**CITY OF ALBUQUERQUE
PLANNING DEPARTMENT
September 30, 2015
DRB Comments**

PROJECT # 1010378 APPLICATION # 15-70345

RE: Lots 10A & 10B, Candelaria Plaza Addition

PROJECT: 1010378  
 DATE: 12-9-15  
 APP: 15-70439  
 READER: PIF (PLAT)

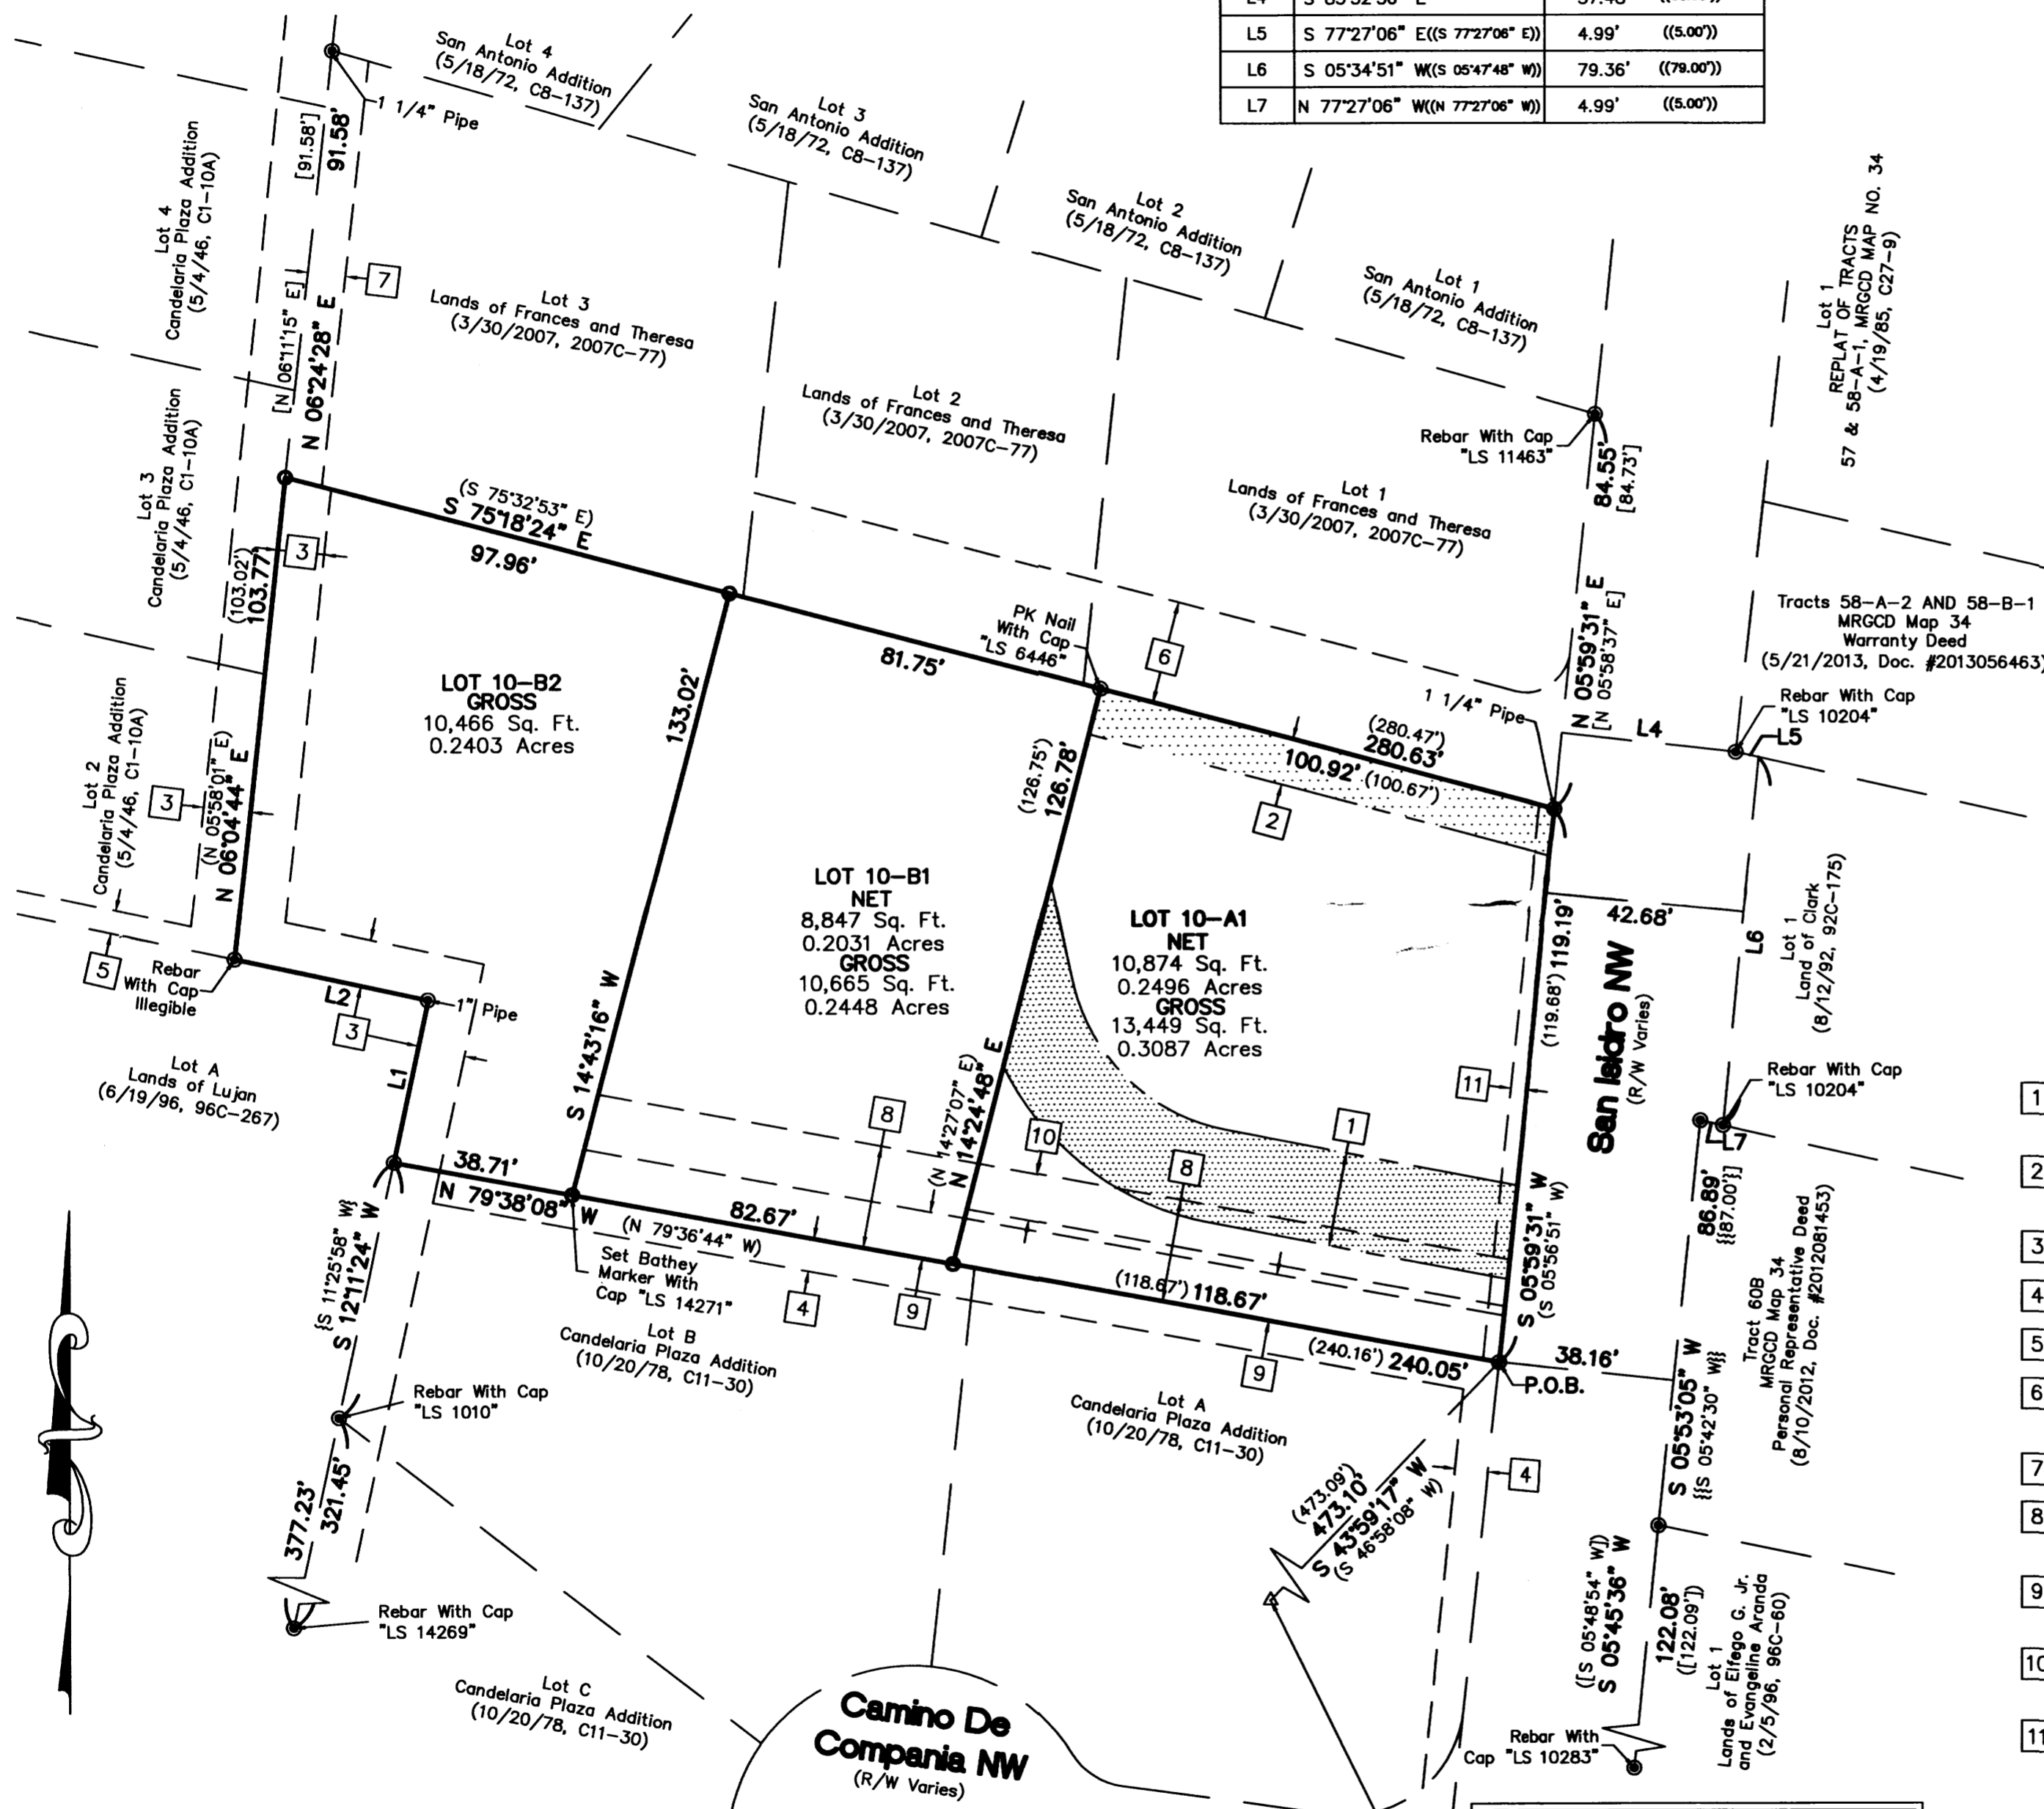
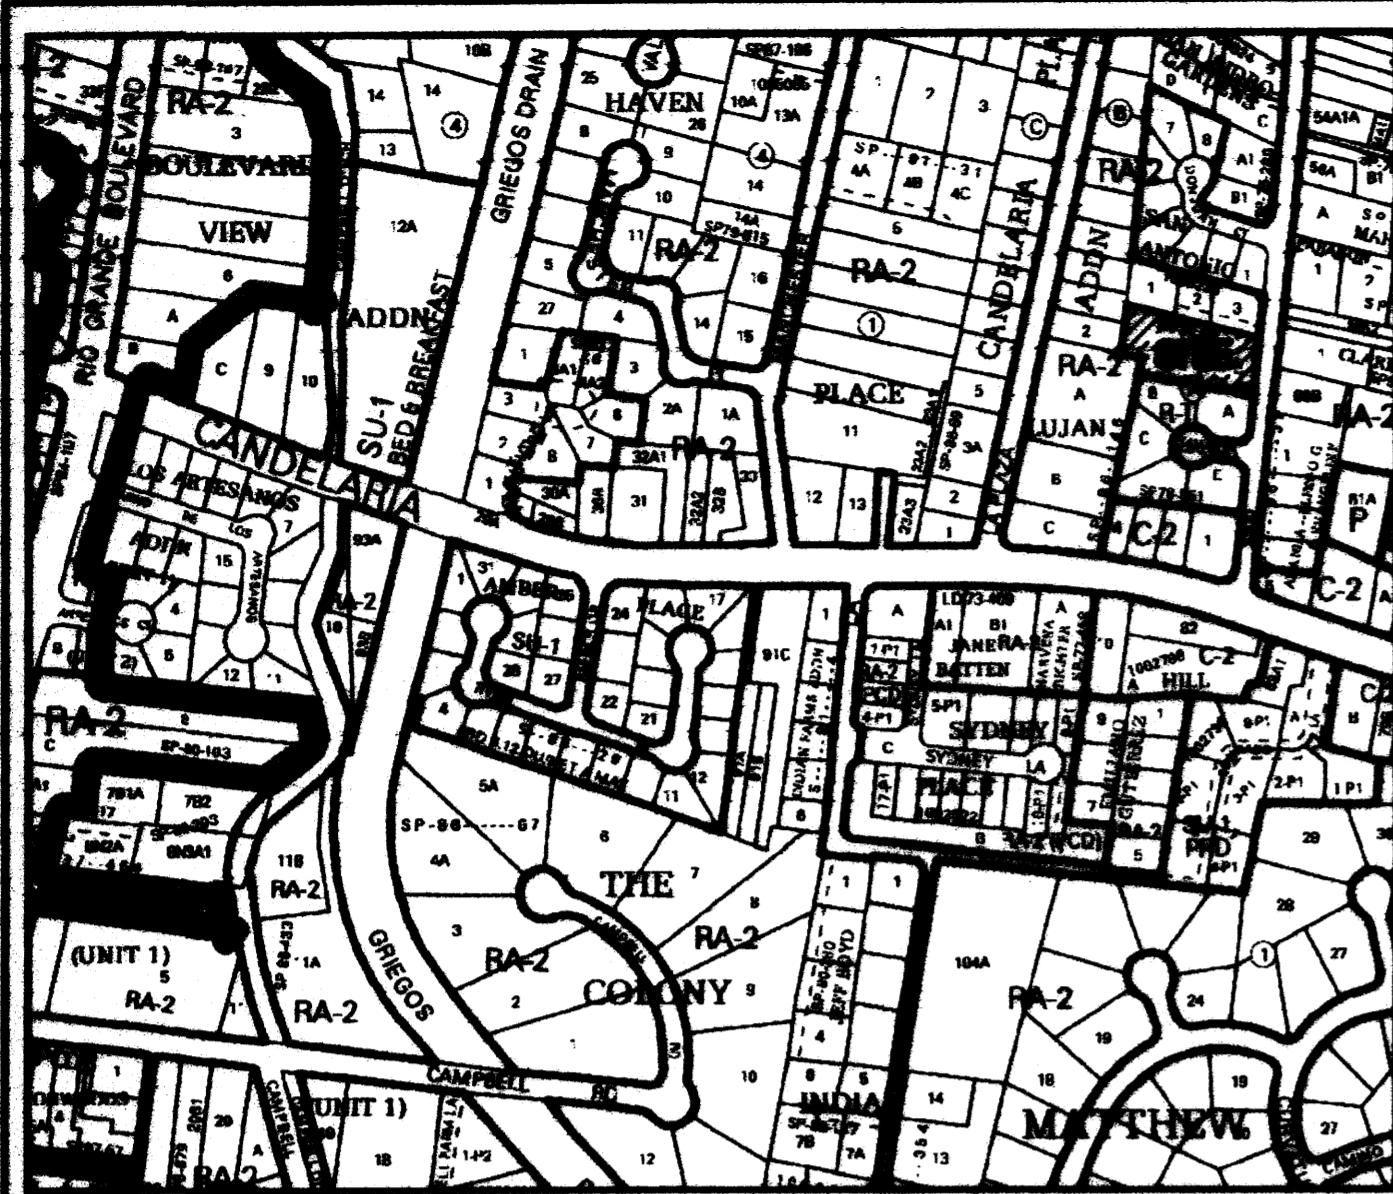
RA-2 zoning requires a minimum .25 acre Net (exclusive of access easements). A Lot Area Variance would be required for proposed lots 10 B-1 and 10 B-2, and if the Variances are specific they would need to match the proposed plat.
